ASI

4500 Paseo Del Norte NE
Traffic Circulation Layout

Response to review dated July 14, 2021

Date: July 14, 2021
Sheet: Traffic Control Layout

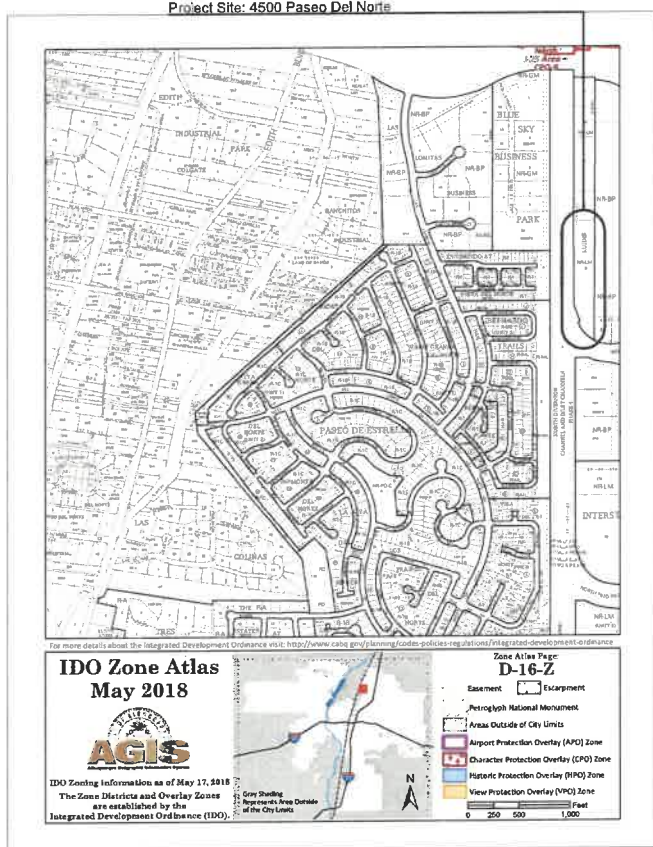
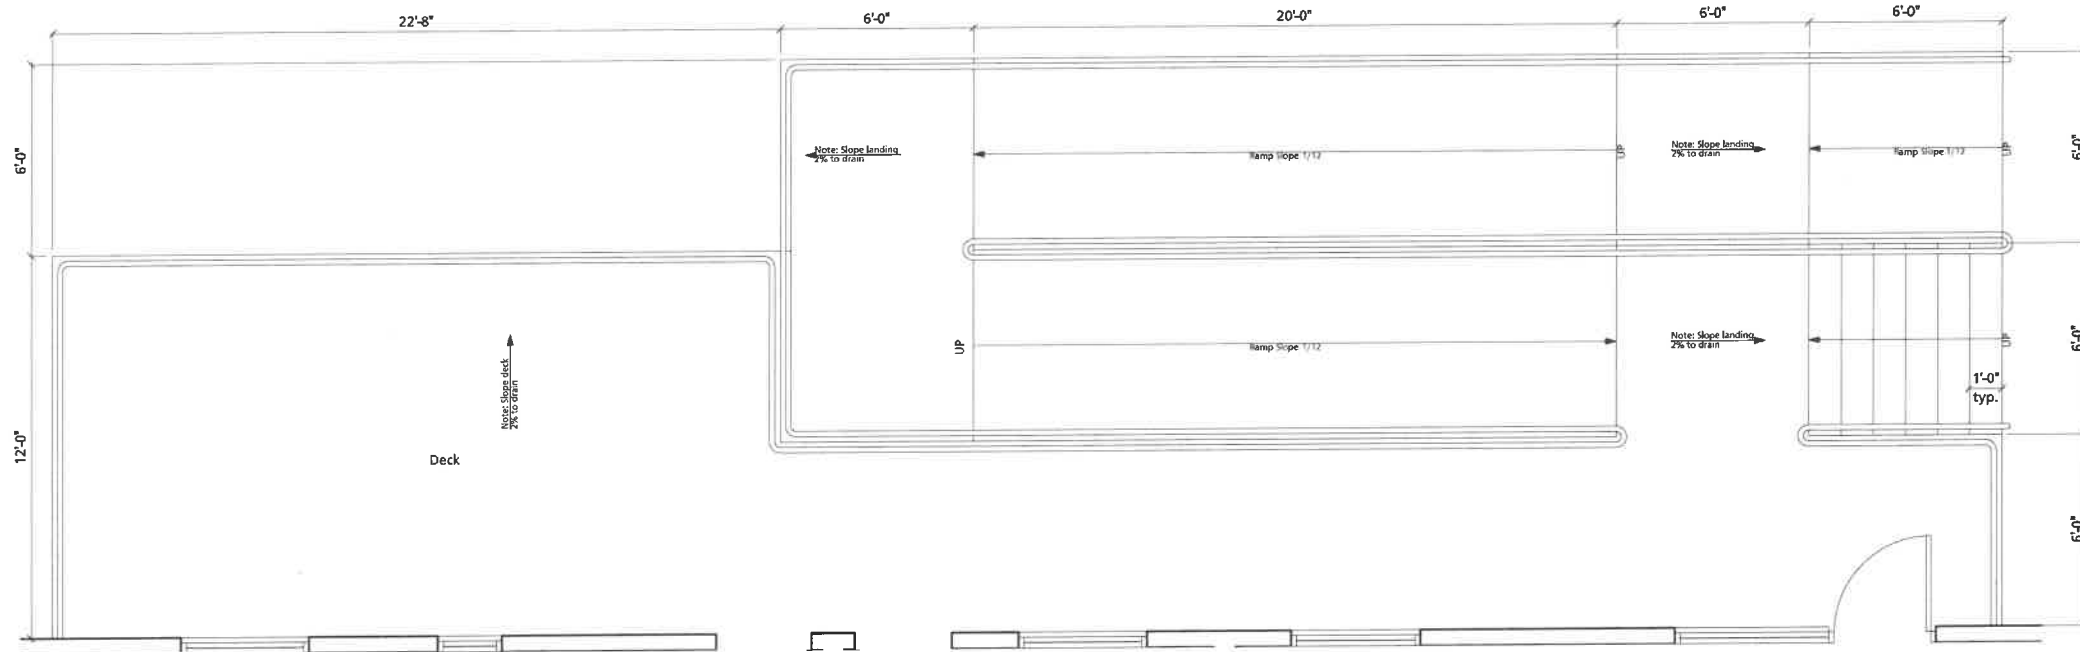
1.a. I spoke with Jeanne and we agreeded that we did not need any sidewalk and the existing access road is adaquate.

1.b. there is no public sidewalk to connect to.

1.c. thee is no street adjacent to this property.

Sheet: Enlarged Ramp / Stair Details

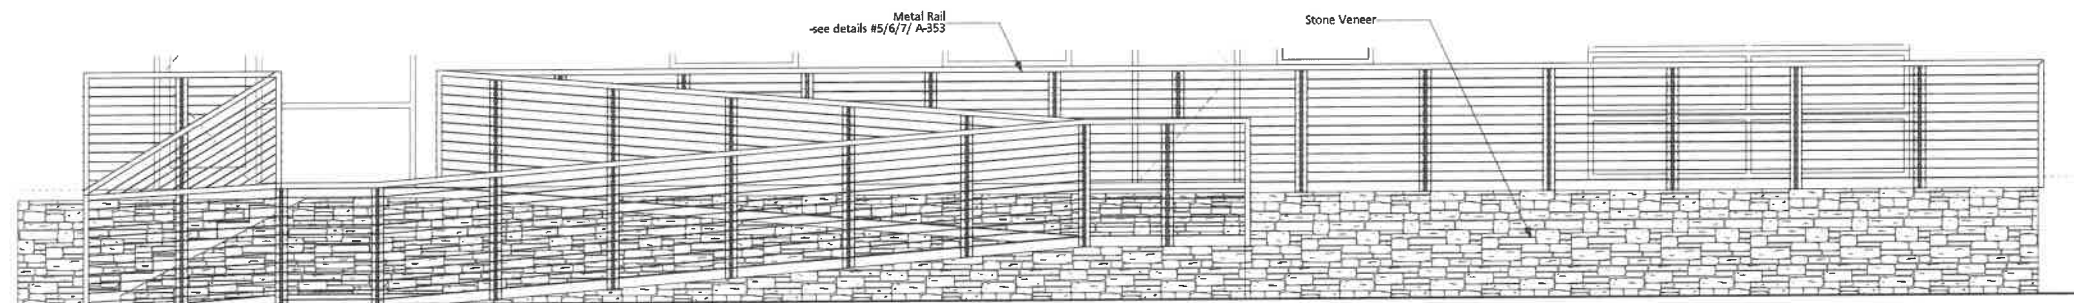
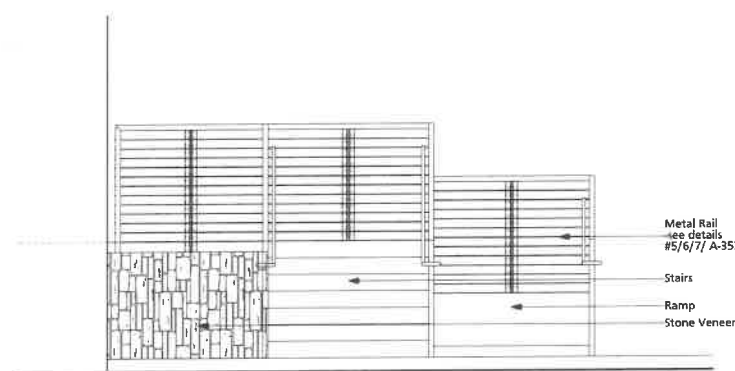
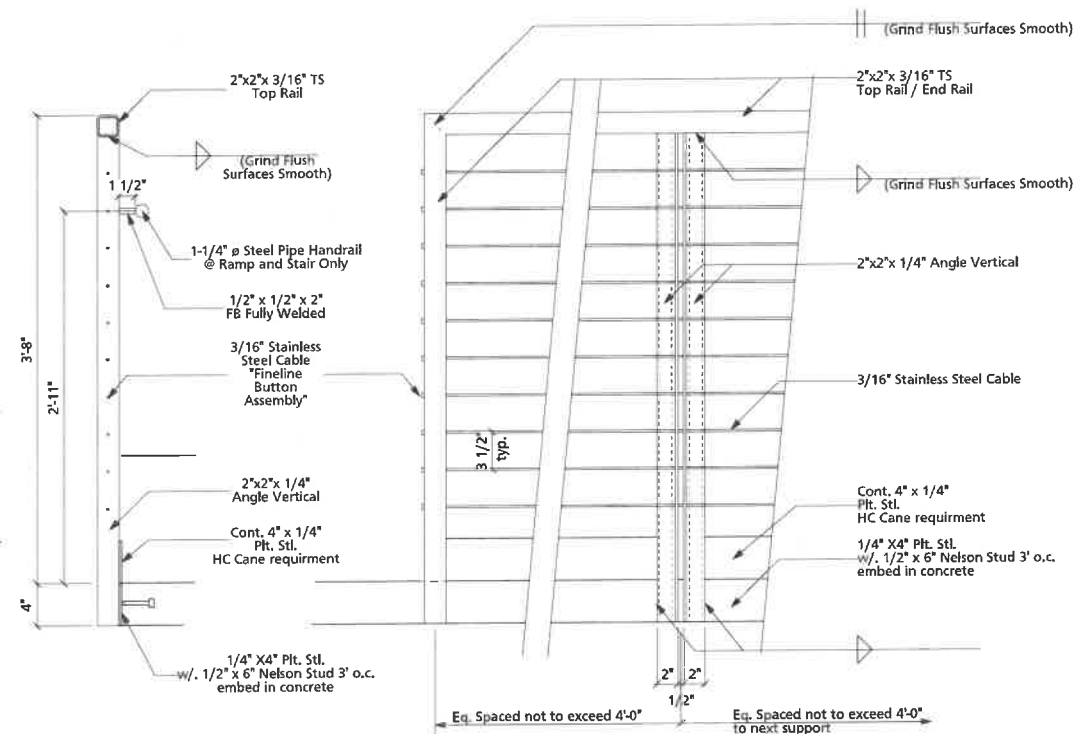
2. The HC space is level with the entry ramp.
